CITY OF ALBUQUERQUE

August 30, 2024

Re: Sonic
9701 Bluewater Rd.
30-Day Temporary Certificate of Occupancy
Transportation Development Final Inspection
Engineer's Stamp dated 08-03-23 (K09-D048C)
Certification dated 08-20-24

SITE PLAN

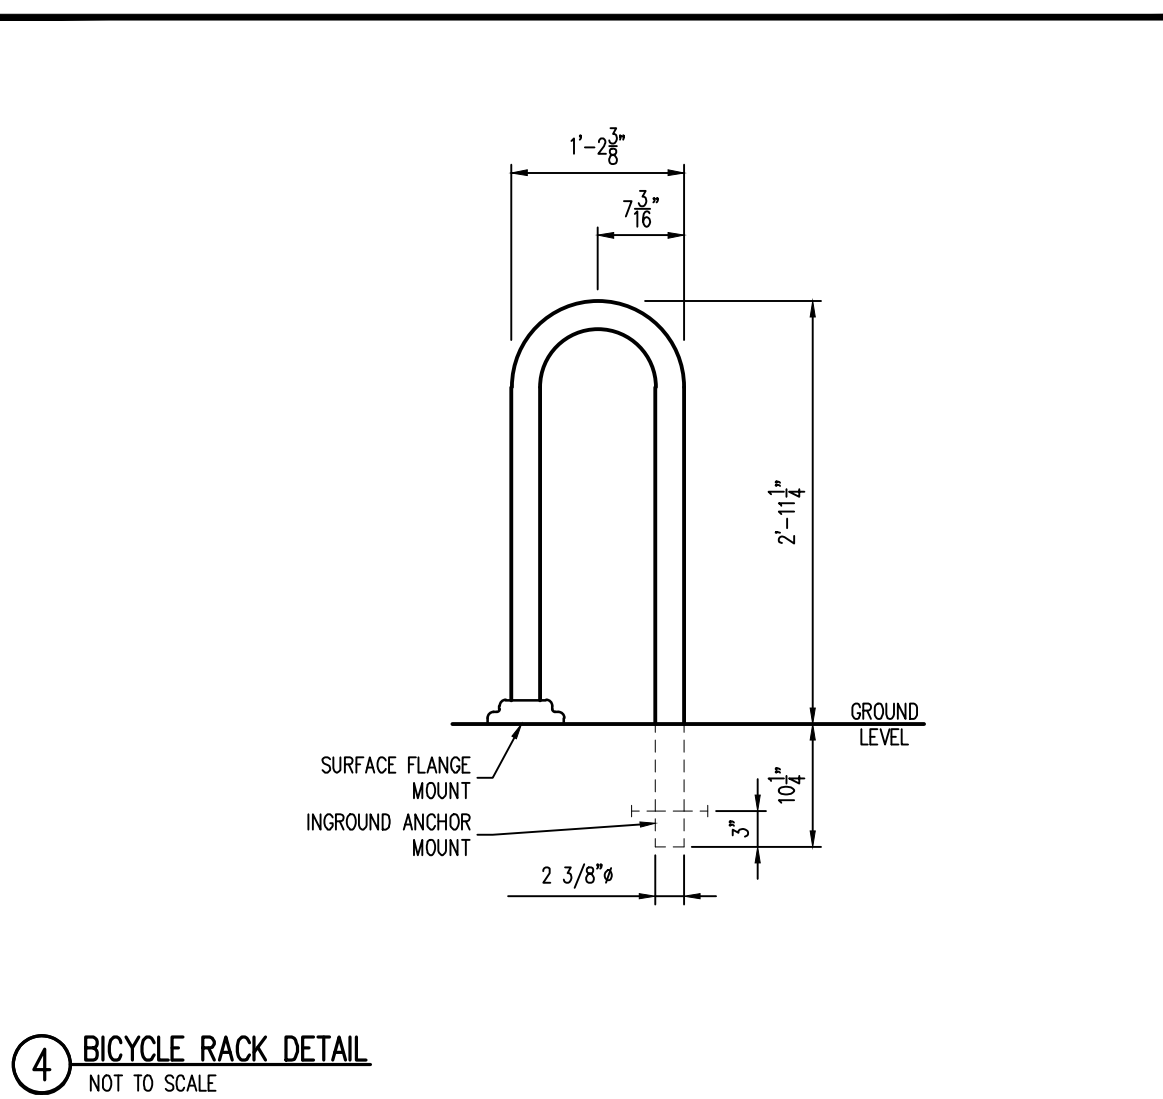
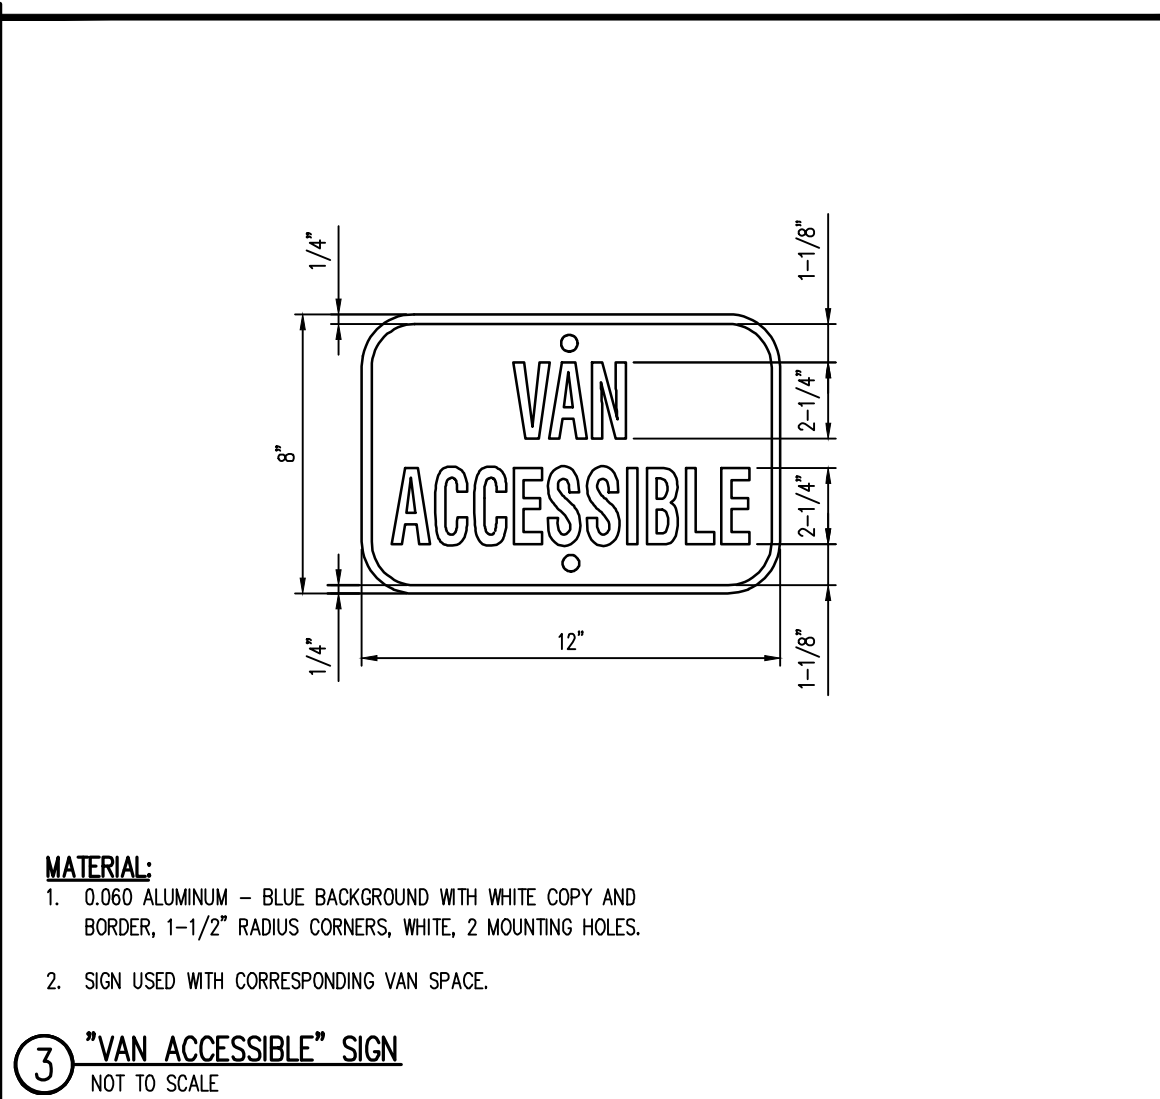
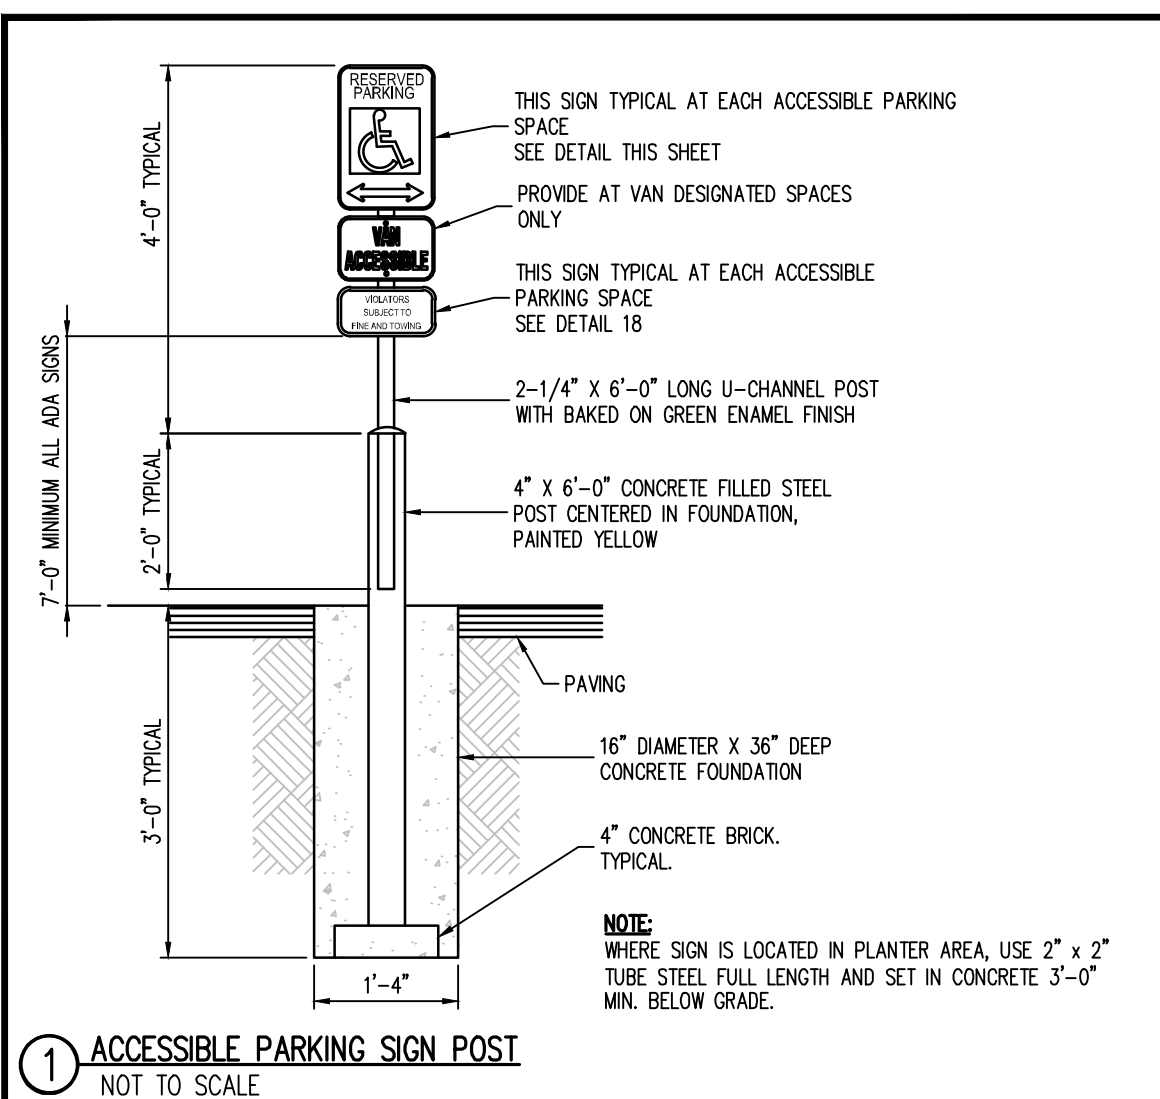
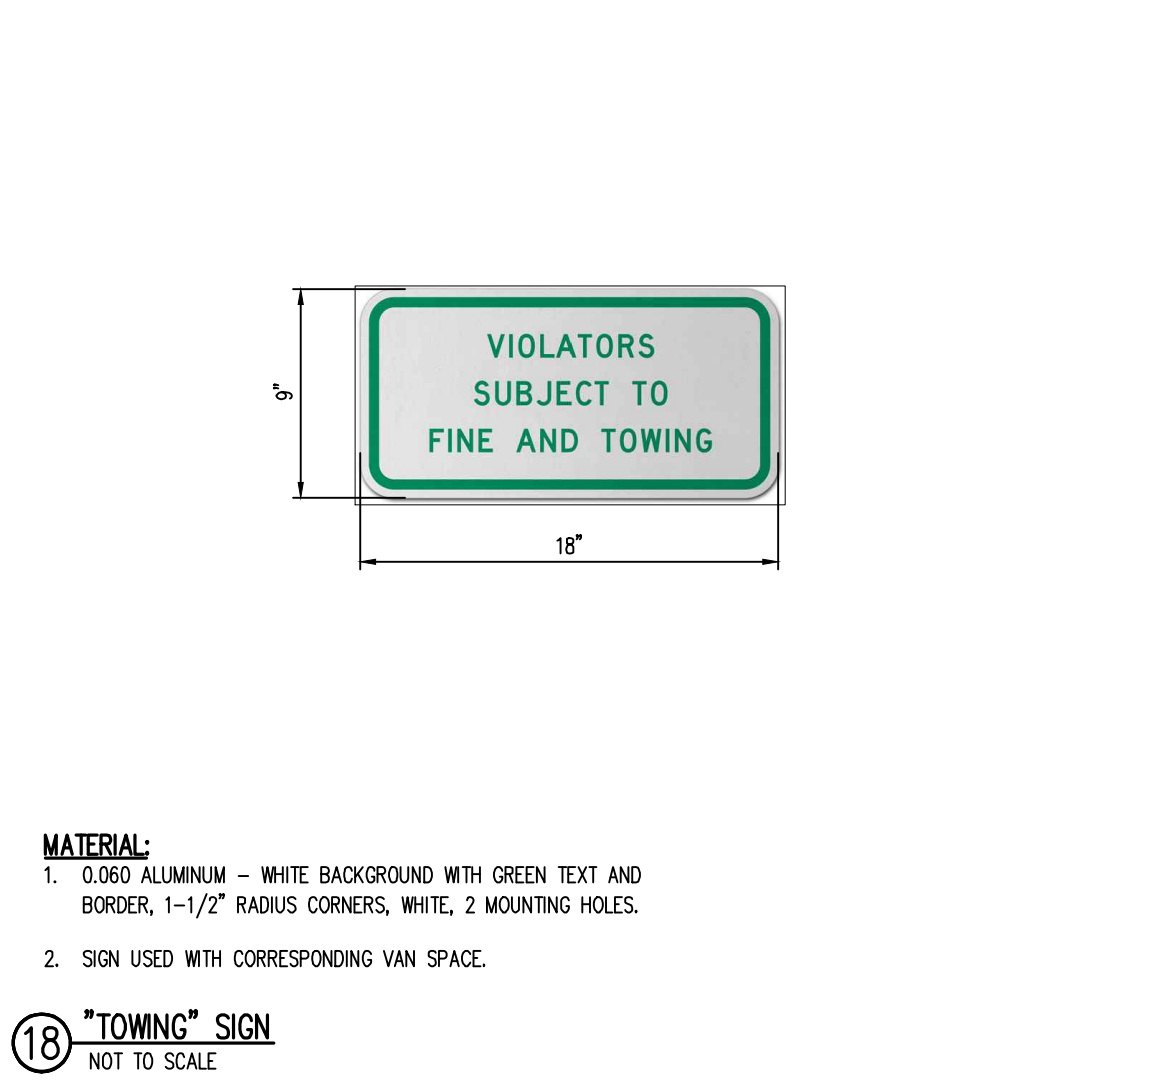
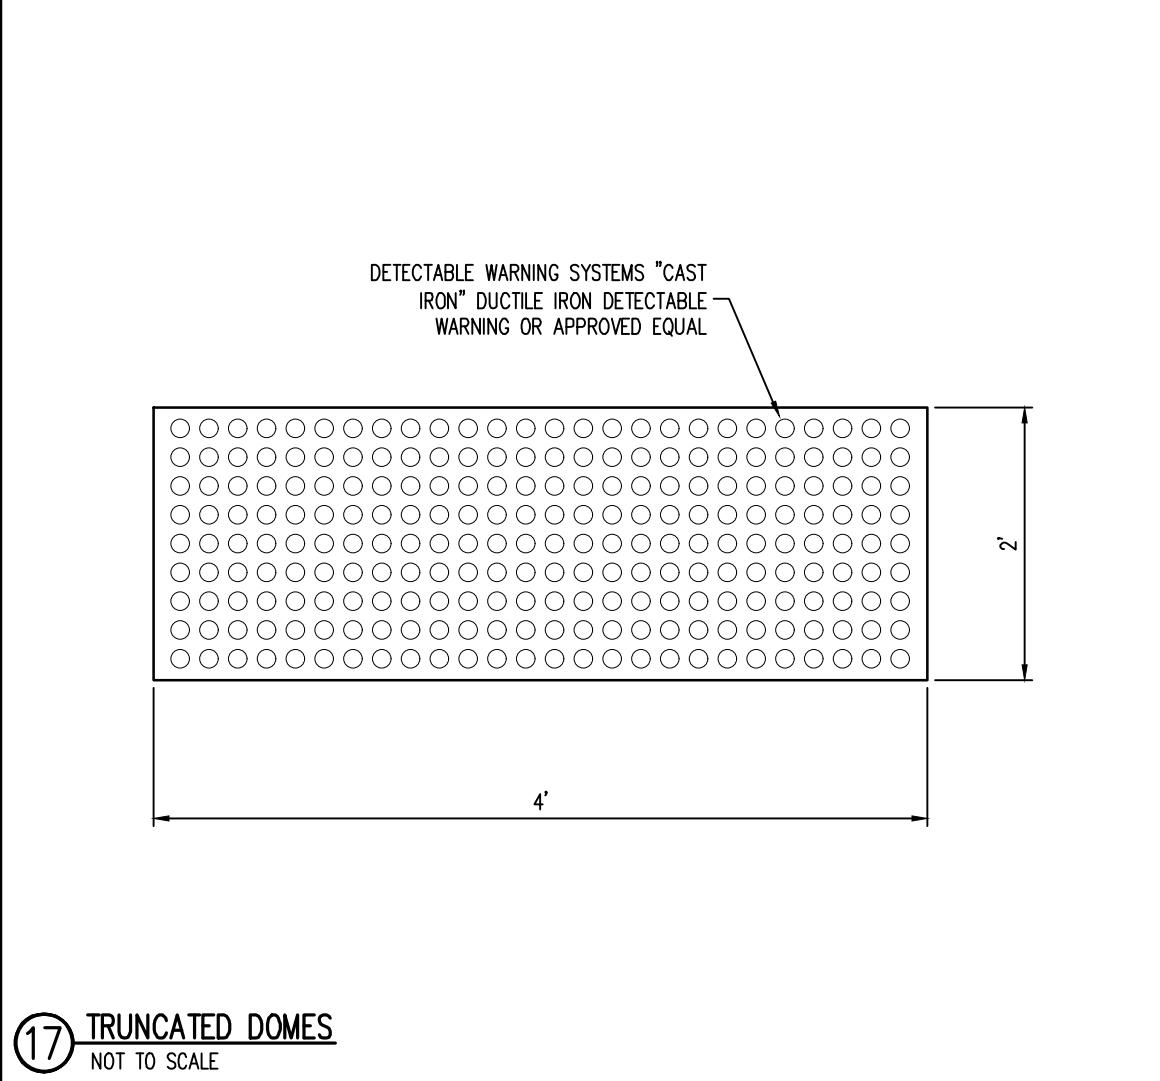
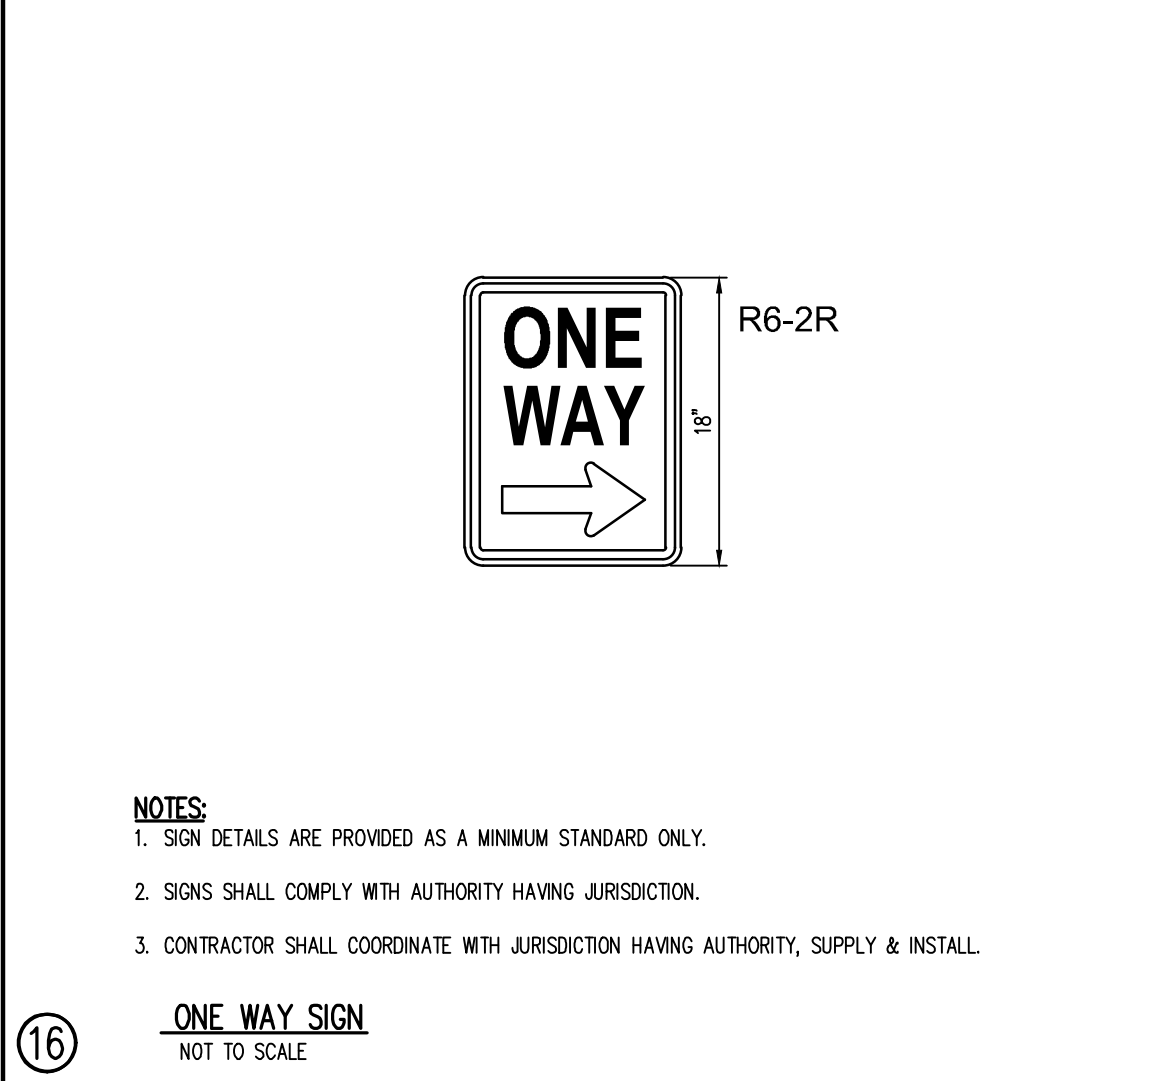
- Per approved site plan, keynote 29: a "DO NOT ENTER" sign must be provided at the southeast site exit.

- The approved site plan and parking table indicate that 4 bicycle parking spaces should be provided. However, per site visit, only one bike rack hoop was provided (which accommodates only two bicycles), please either red-mark the parking table on the site plan to reflect this change, or provide an additional bike rack to meet the parking table requirements.
